KITTITAS COUNTY DEPARTMENT OF PUBLIC WORKS

MEMORANDUM

TO: Jeff Watson, CDS
FROM: Christina Wollman, Planner II *W*
DATE: September 1, 2010
SUBJECT: Boehm VA-10-00005

LINDLEY'S ADDITION PLAT

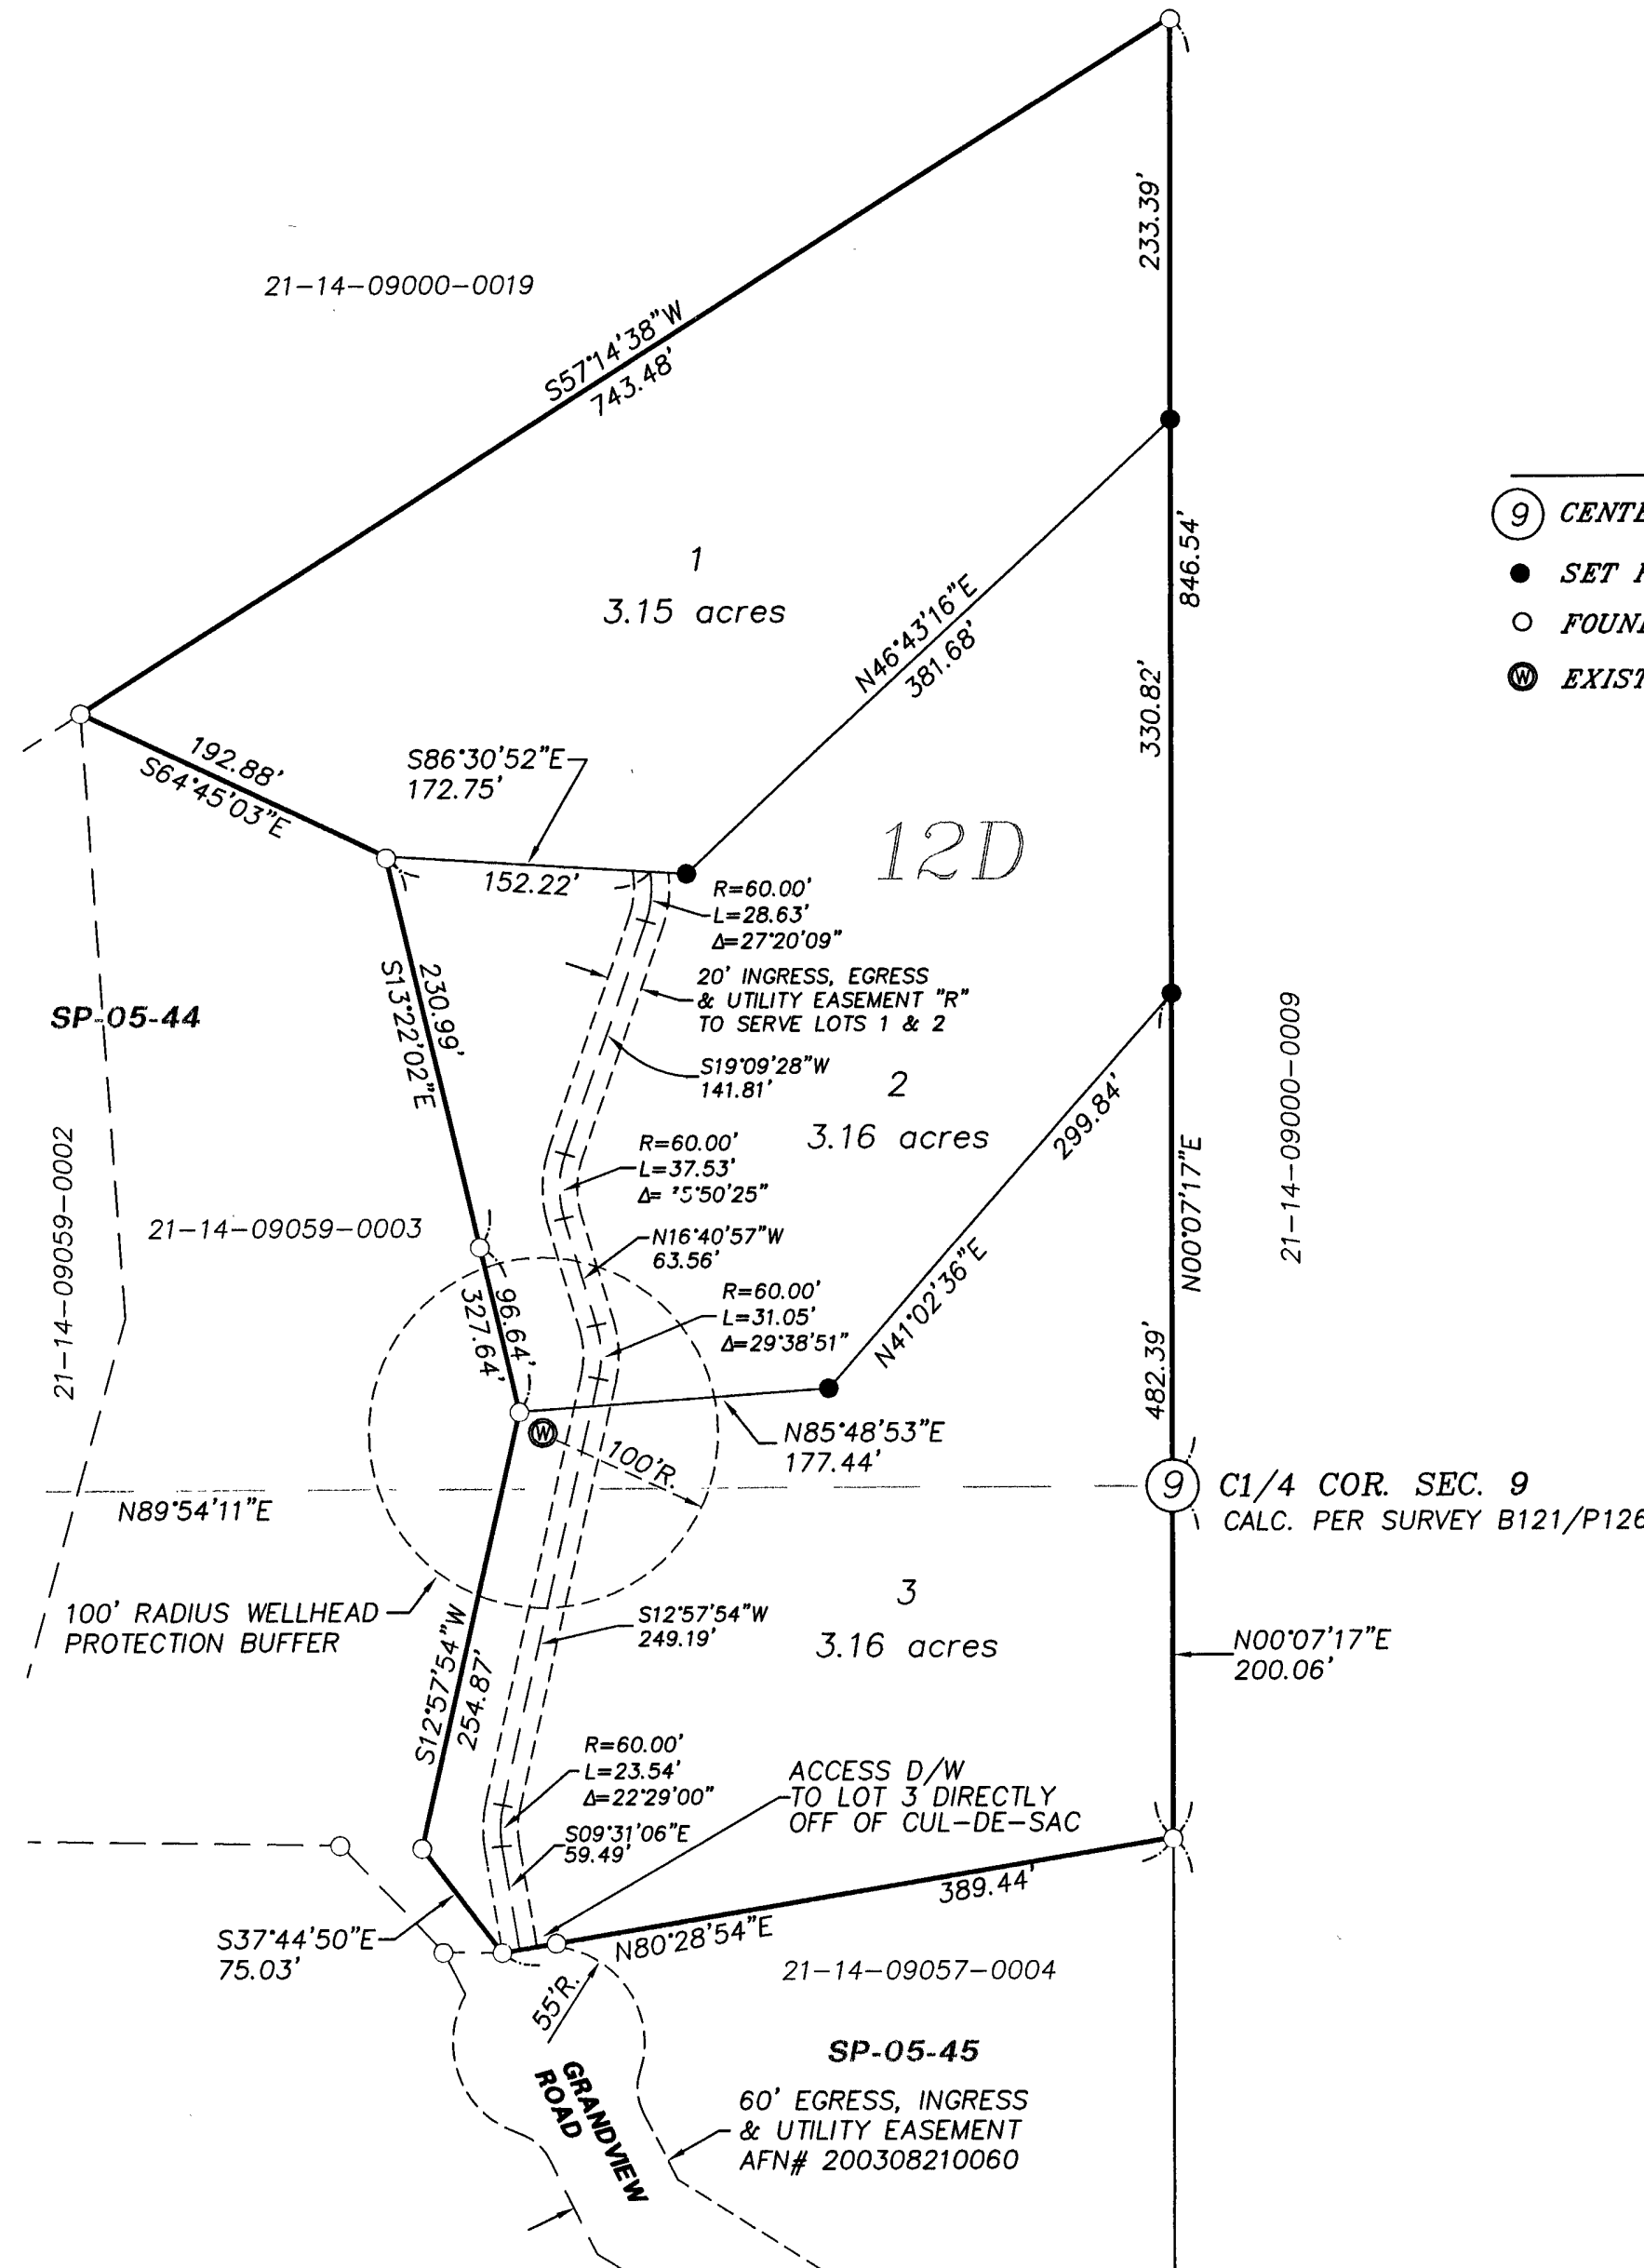
Although Public Works does not have any concerns with the proposed variance, the proposed driveway as shown on the site plan does not correspond to the final plat and will not be allowed. During the platting process, access to lot 3 was designated to come directly off the cul-de-sac at the end of Grandview Road. This was to avoid any additional road improvement requirements, and is noted on the plat (attached).
